Response to Submission comments for Intercontinental Hotel: MOD 2 - Insertion of Stage 1A (SSD-7693-Mod-2)

Tim Smith OAM
Director, Assessments
Heritage NSW
Department of Planning & Environment
As Delegate of the Heritage Council of NSW
16/6/22

Figure 1: Section A for Stage 1a Transport House Function Room Envelope by Coffee Parker, Drawing number 3101 dated 7 December 2021².

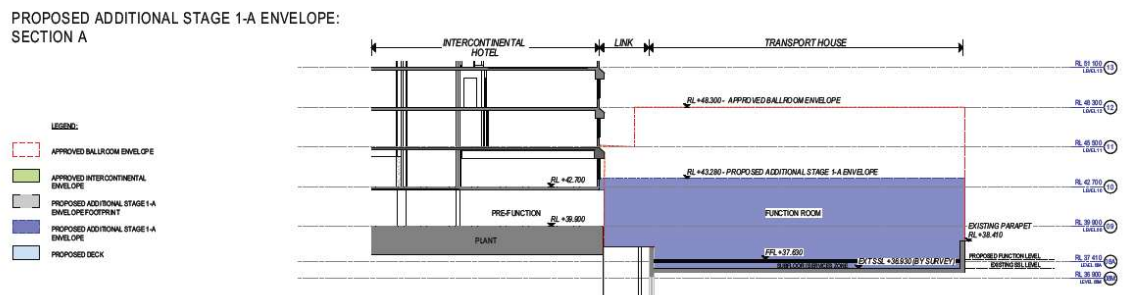
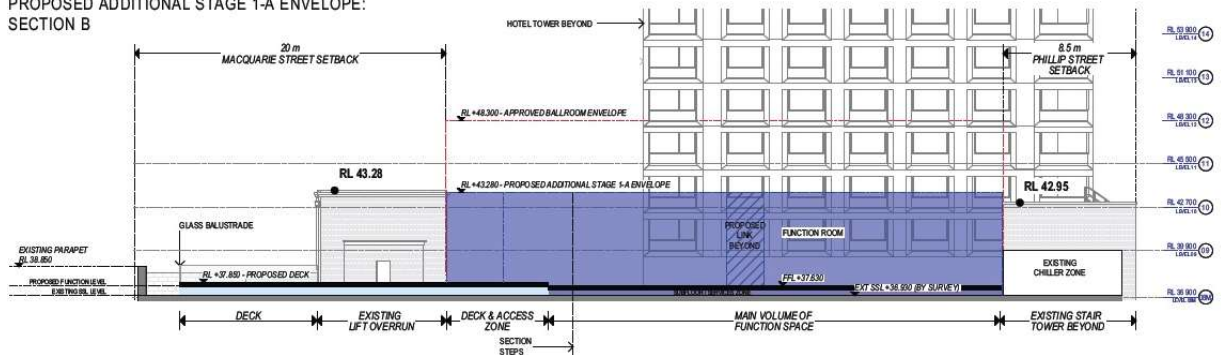
- The parapet is approximately 450mm lower along the sides, further away from the building line. A visual analysis of this reduced height in angled views has not been provided. This is especially relevant for views from the south where visibility is high due to the adjacent building being lower and the setback provided being only 2m. It is likely that there will be a much higher visual impact along the south side. The setback along the south parapet should be more than the front in order to mitigate this impact.

- There is no valid justification for the proposed roof deck to be 900mm higher than existing level and 220mm higher than proposed function room level. The effective existing parapet height is only 1m meaning occupants and any tall element will be visible in views. It is recommended that the floor level is lowered to match or preferably be lower than the proposed function room level.
